Sikh Grammar School Rouse Hill (SSD-9472)
Request for Additional Information

I refer to Response to Submission (RTS) and Supplementary RTS for the Sikh Grammar School Rouse Hill (SSD-9472). After careful consideration, the Department is requesting that you provide the following additional information:

5. Appendix A – Proposed Development Detailed Staging Plans

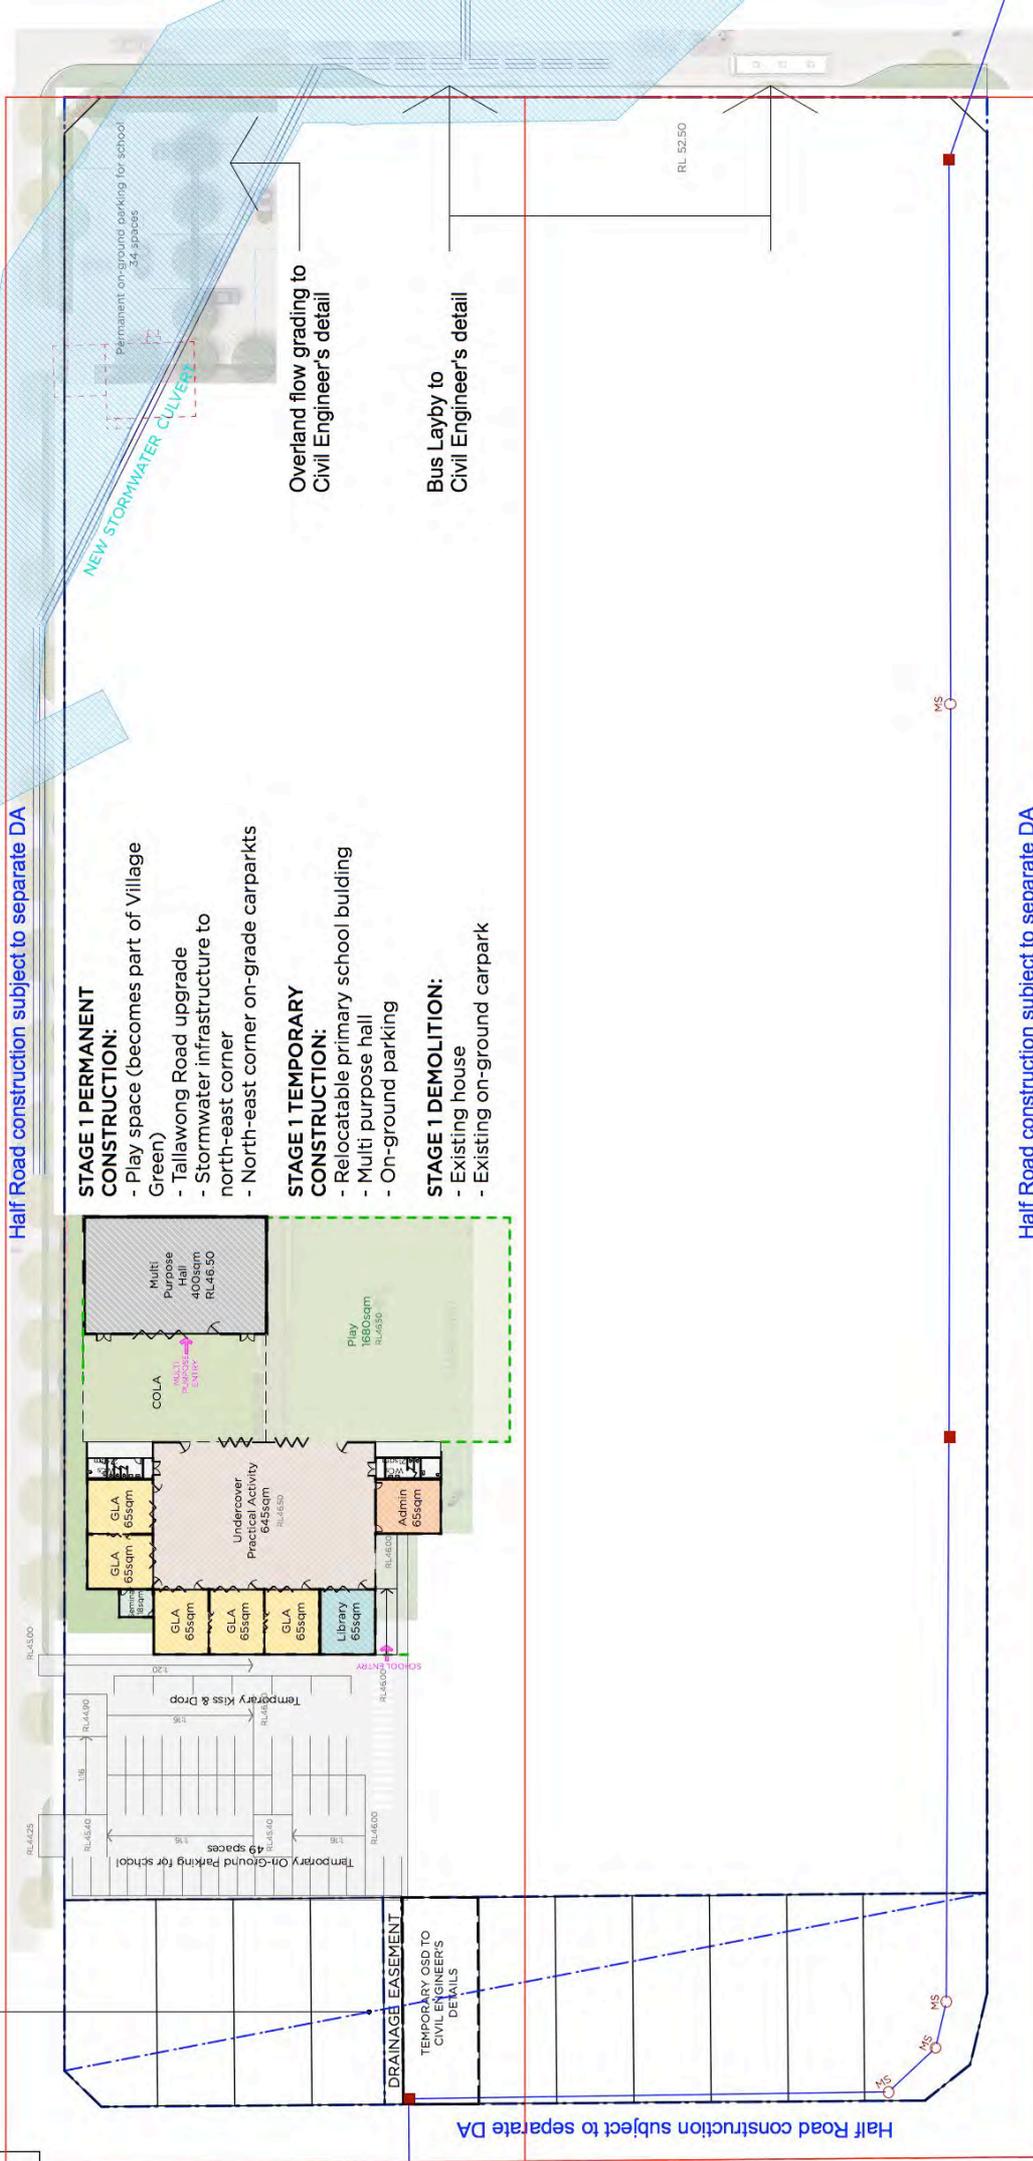
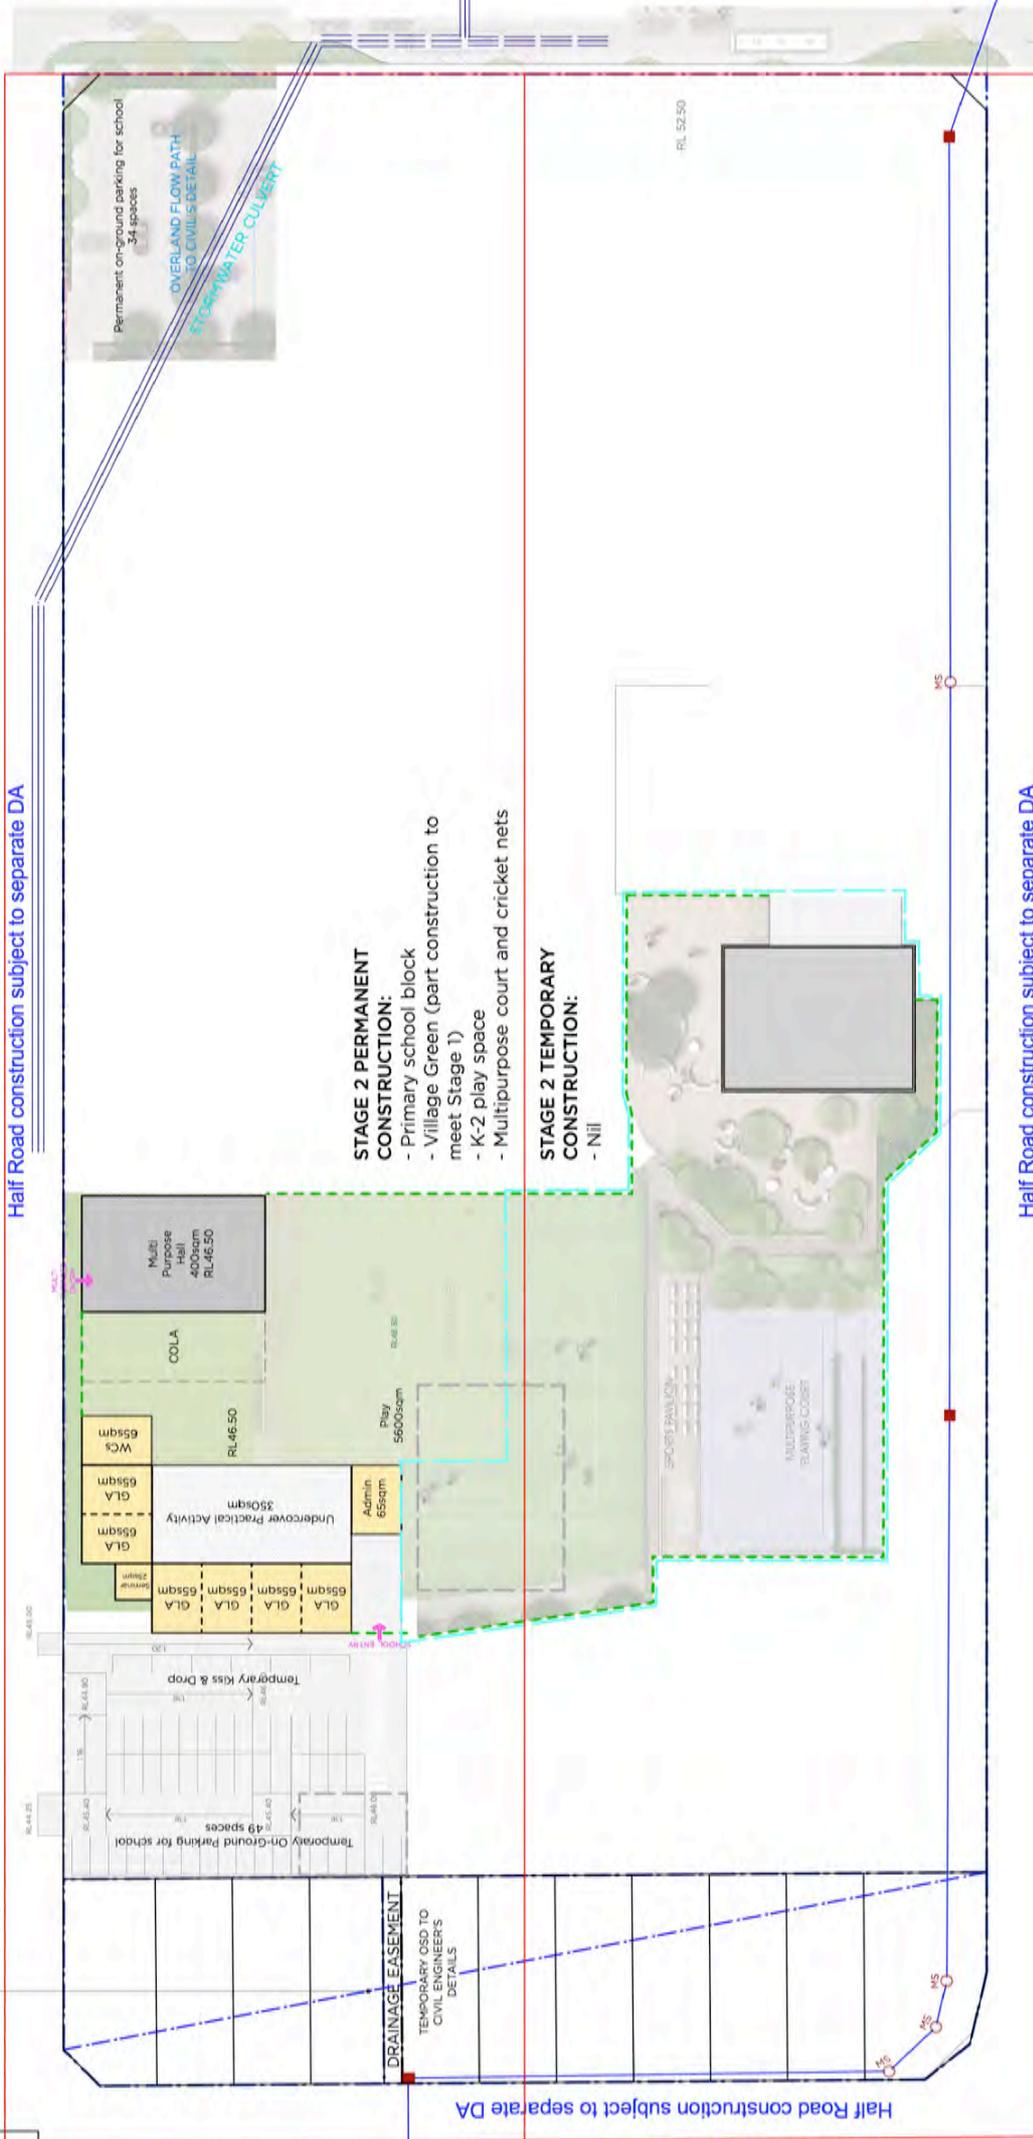
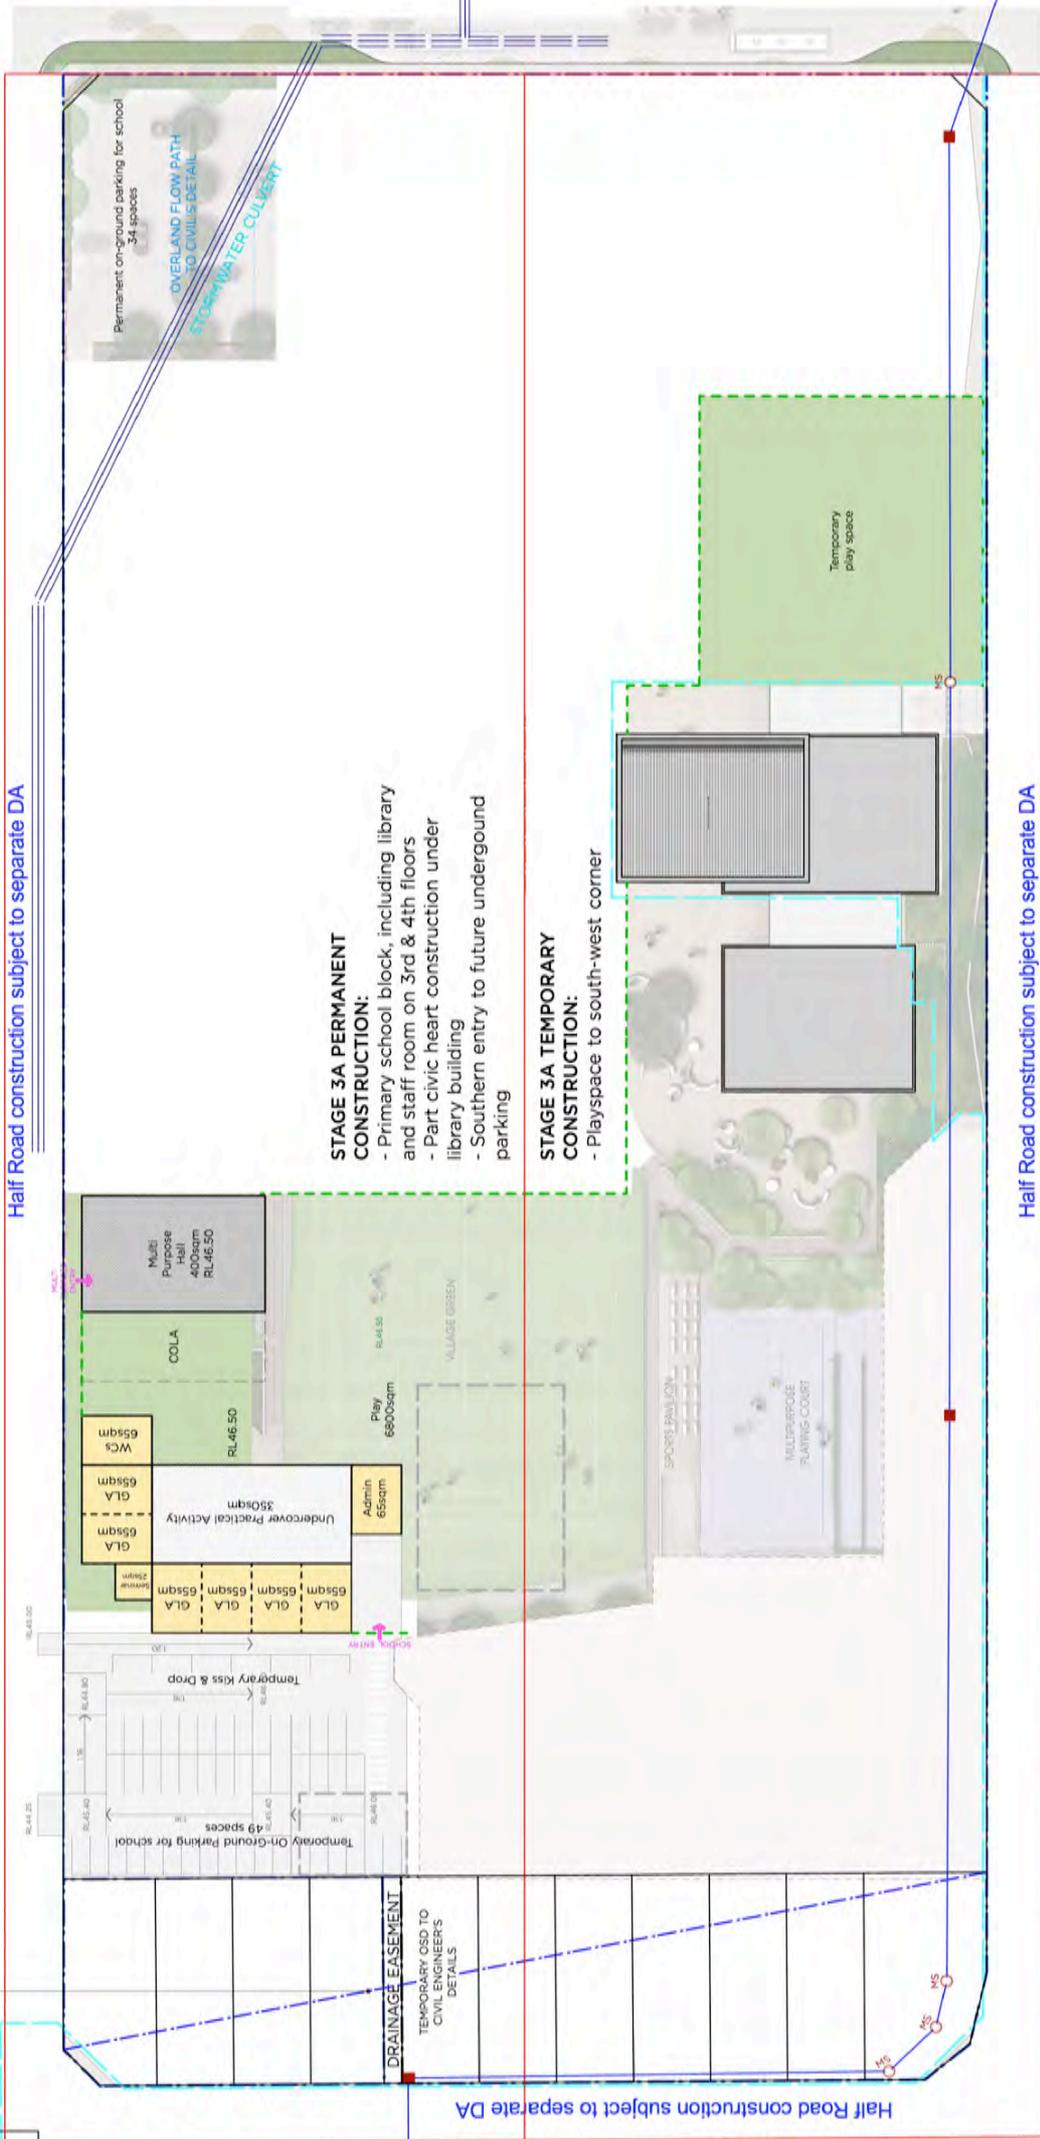
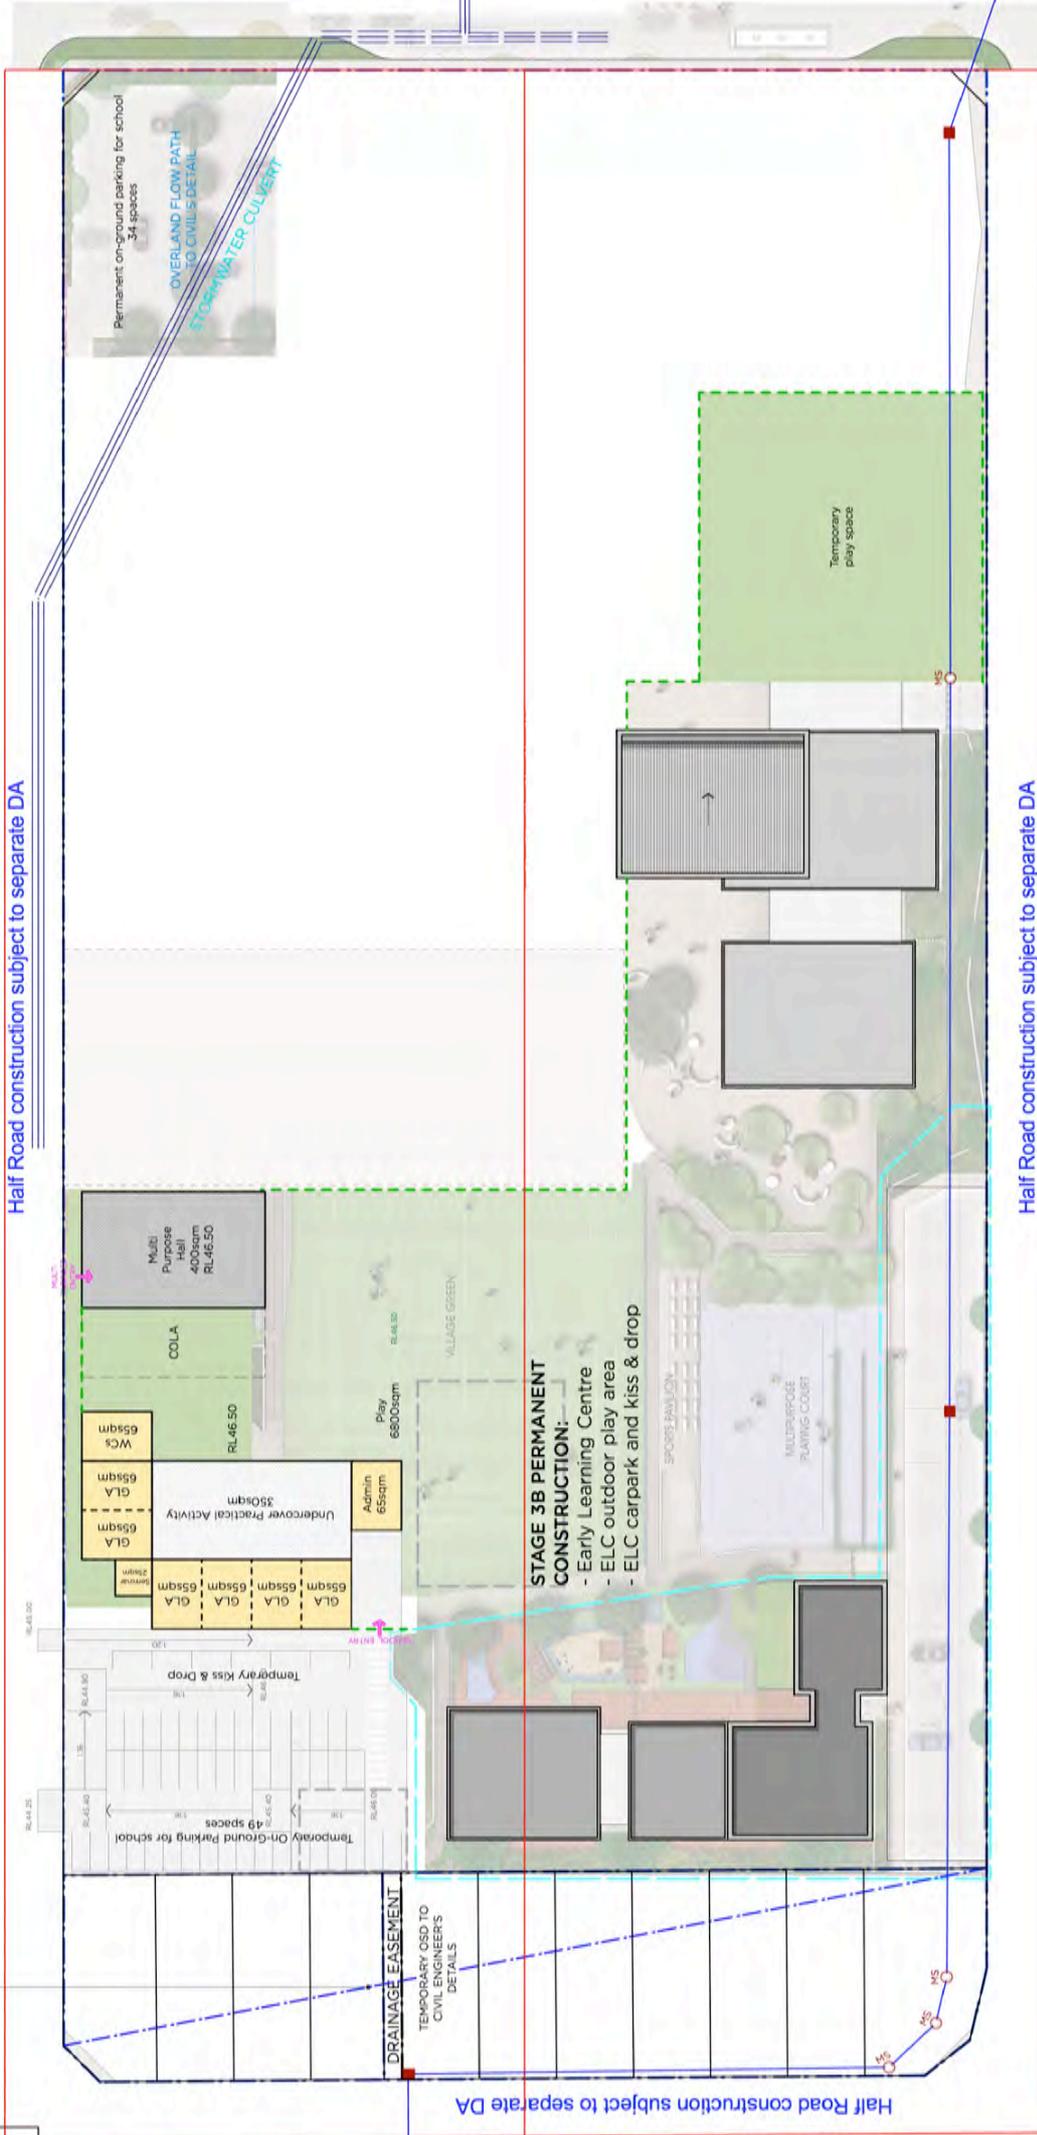
It is noted that throughout all the submitted documents (EIS report, RTS report and supplementary RTS) the construction timeframe is stated as 10 years. However, the staging plans in the Architectural Design Report (pages 59- 69 in Appendix 4 of the RTS) reflects 24-year timeframe. These staging plans are to be revised to reflect a 10-year construction timeframe so it's consistent with the submitted documents.
